THE SIZEWELL C PROJECT

DEADLINE 2

SUMMARY OF WRITTEN REPRESENTATION SUBMITTED BY THE HEVENINGHAM HALL ESTATE (THE HHE)

DRAWING TITLE:
NORTHERN PARK AND RIDE
PROPOSED PARAMETER PLAN

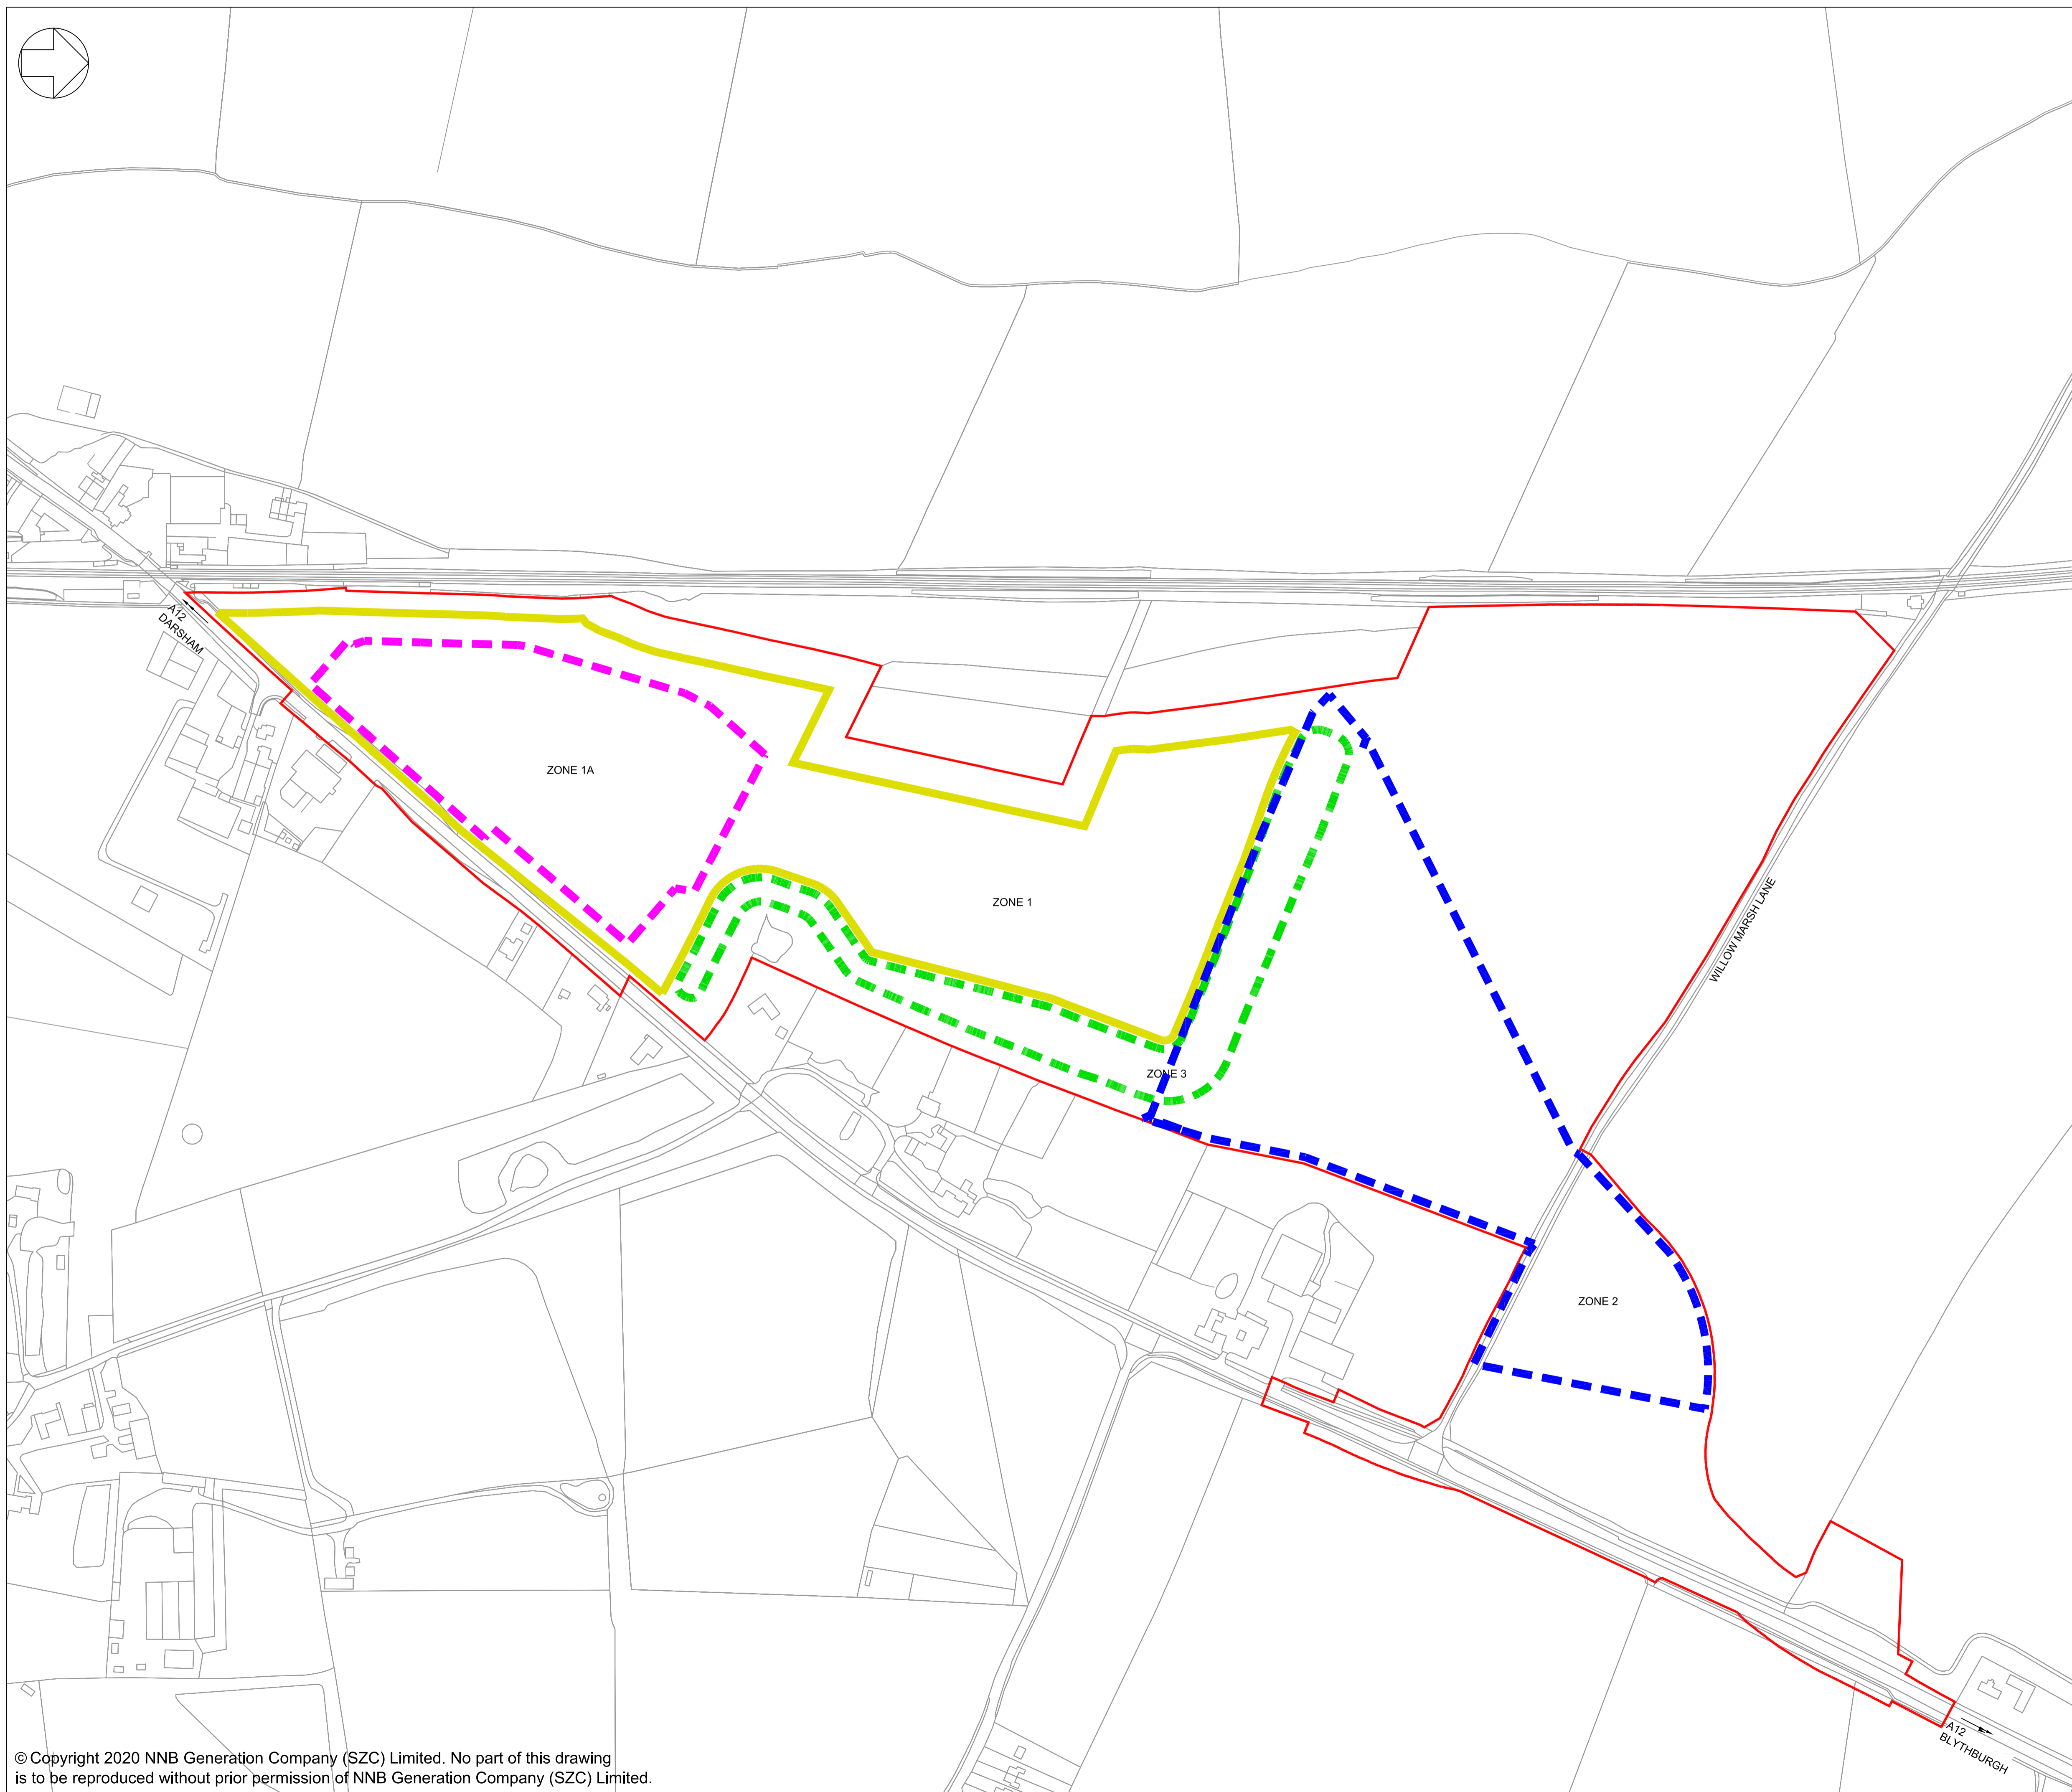
- 1.2 Transport
- (a) The HHE's principal concerns in respect of the Northern Park and Ride (**NPR**) relate to (1) the site selection and location for the NPR; (2) the risks associated with increased use of Darsham level crossing; and, (3) the size of the NPR.

- (b) Given the known highway risks associated with the existing level crossing, the high increase in PCUs and the fact no construction workers are now predicted to travel by train, the Applicant's decision to locate the NPR at Darsham seems incongruous.

- 1.3 Ecology
- (a) There are several flaws with the Applicant's approach to identifying the baseline position at the NPR and Little Nursery Wood, which immediately adjoins the NPR to the west. Most of the survey data relied on is inadequate and out of date. There are also issues with the assessments undertaken. Given the critical importance of establishing the baseline position, if potential effects are to be properly assessed, these types of issues and inconsistencies undermine confidence in the Applicant's overall assessment.
